Please ask for: Ms Iqraa Malik
Email: iqraa.malik@terraquest.co.uk
Telephone: 0121 234 1390
Our Ref: BN/152/21/HH
Your Ref:
Date: 22nd November 2021

Application for Planning Permission for Works or Extension to a Dwelling

Development: Erection of single storey front extension to attached garage.
Location: 3 Abercorn Walk Old Rectory Drive Eastergate PO20 3XE

Stage	Planning
Project	Abercorn Walk
Client	Open Design Studio
Drawing No.	2129-OPDS-00-100
Title	Proposed GA Plan
Scale	1:100@A3
Drawn	FA

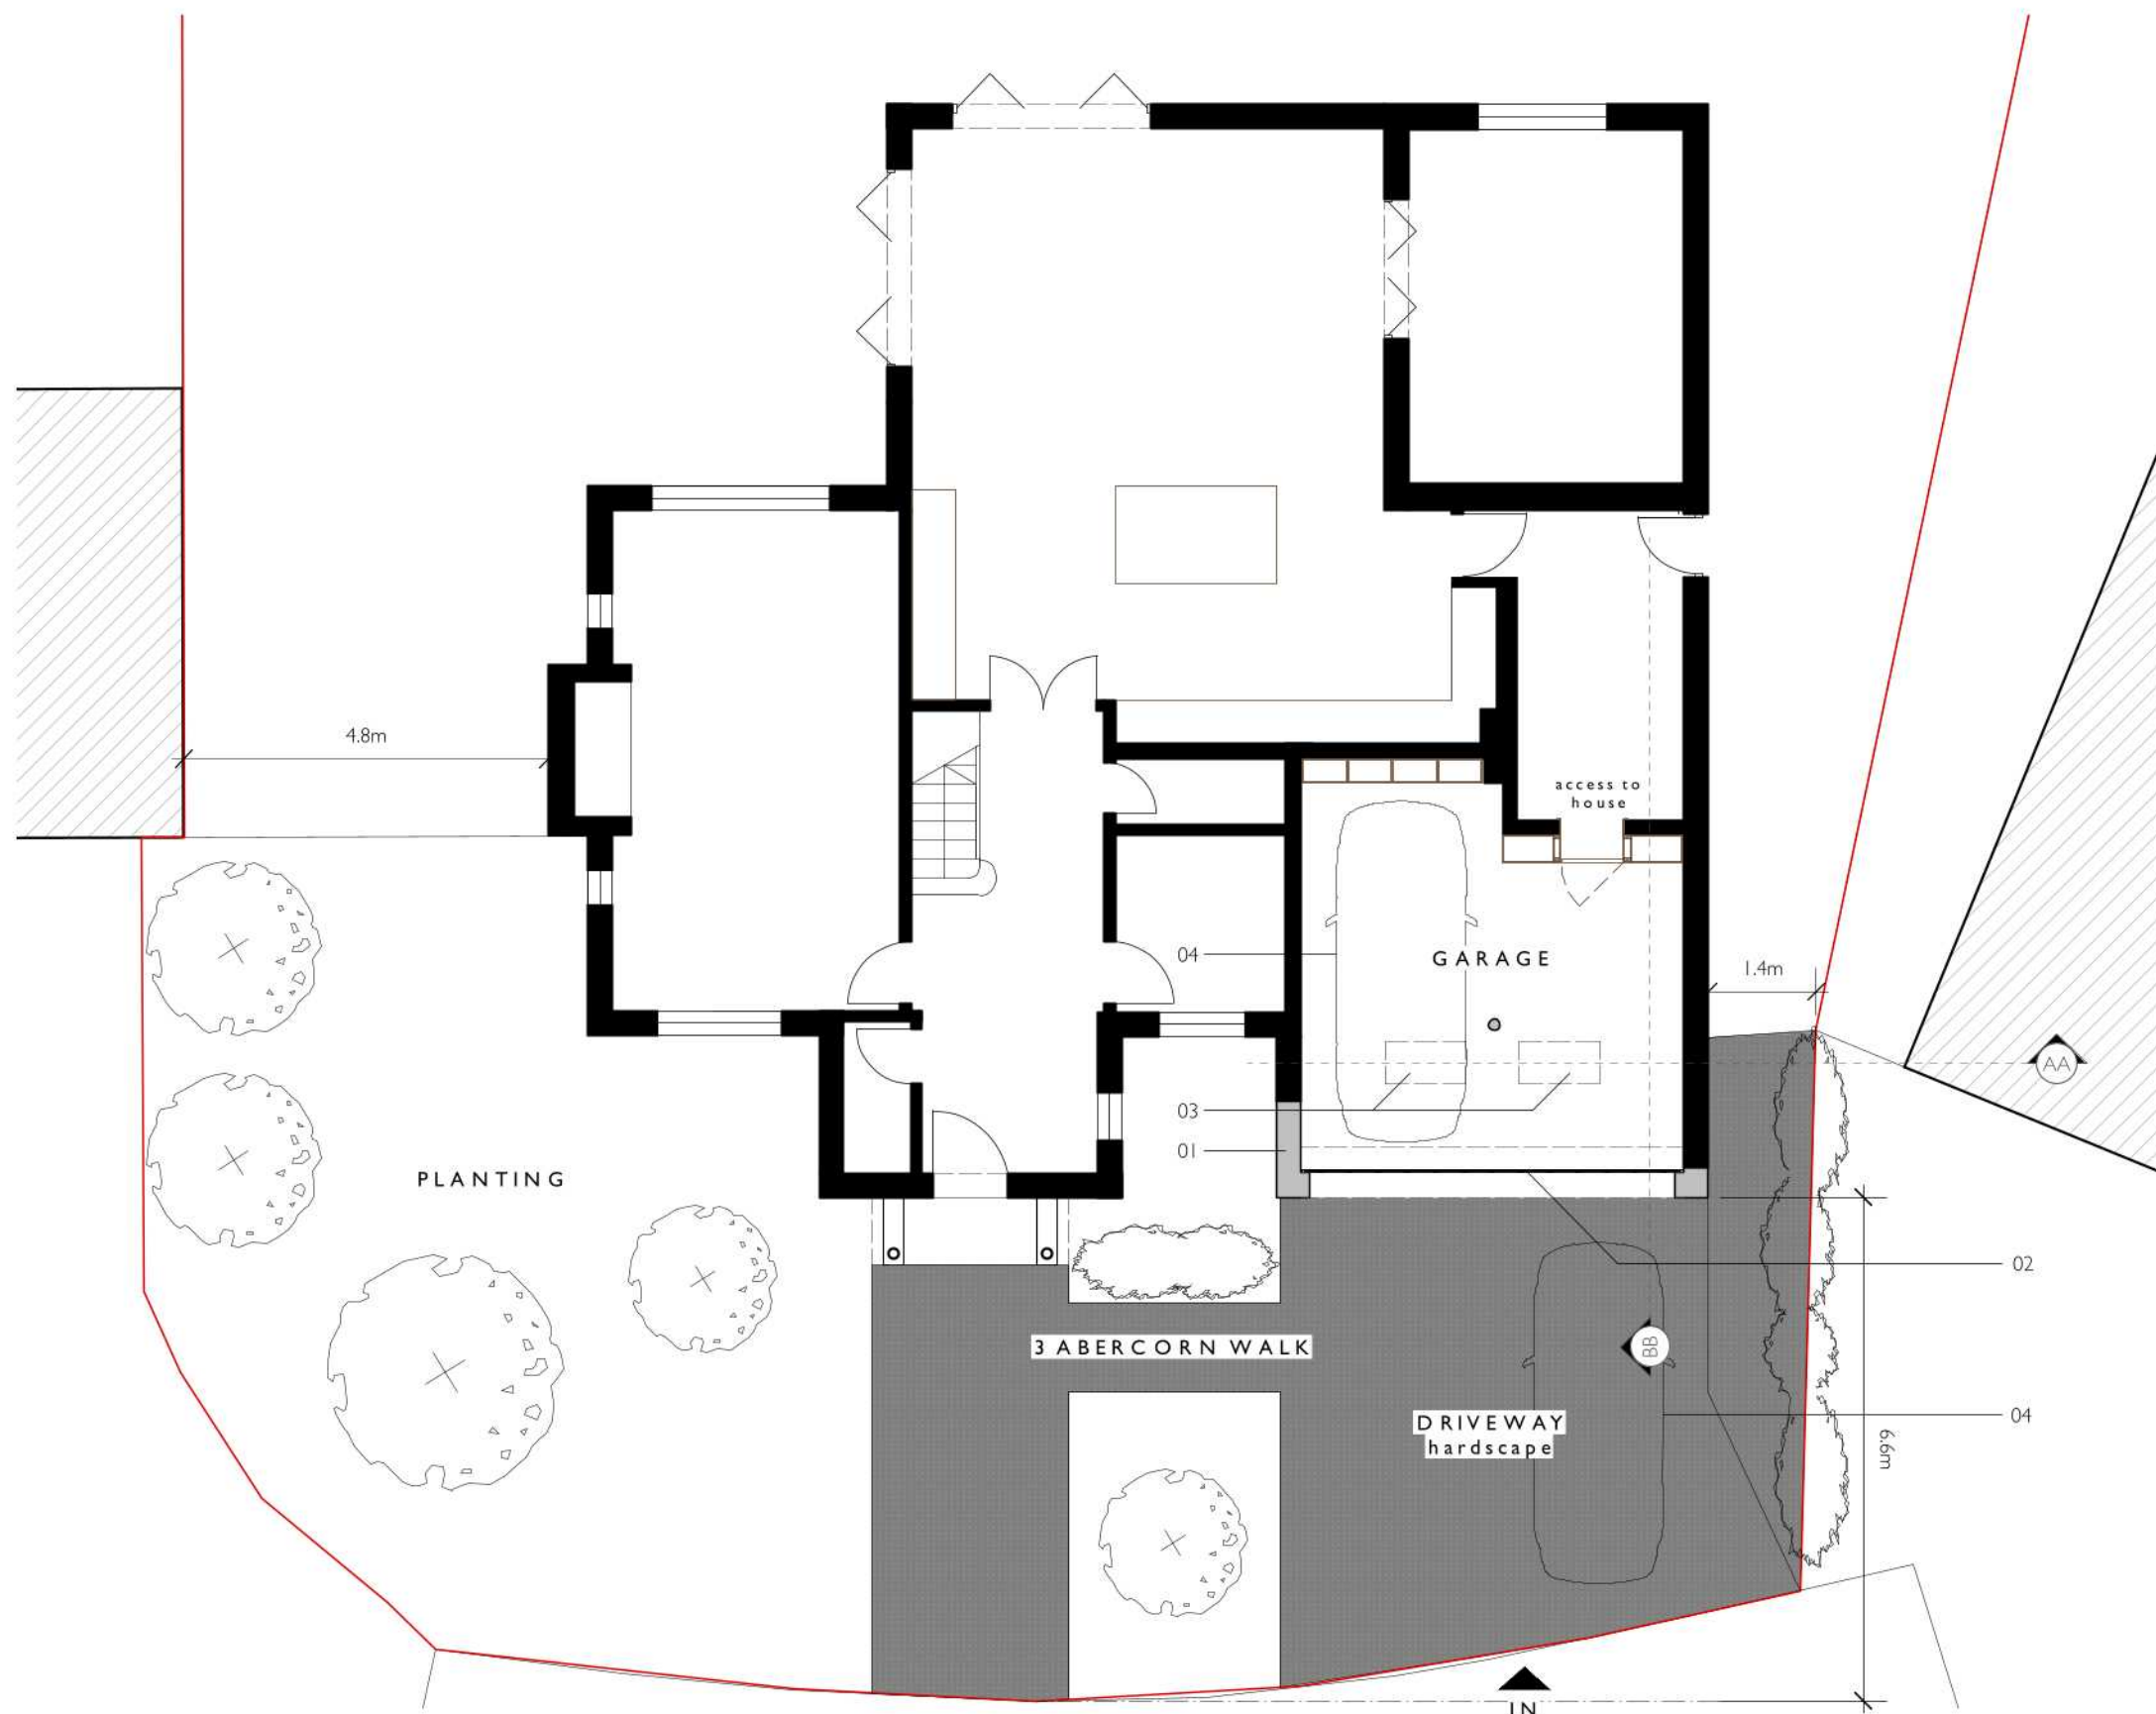
The windows on the existing and proposed North-West Elevations are inconsistent with those displayed on the existing and proposed GA plans. Please review and amend.
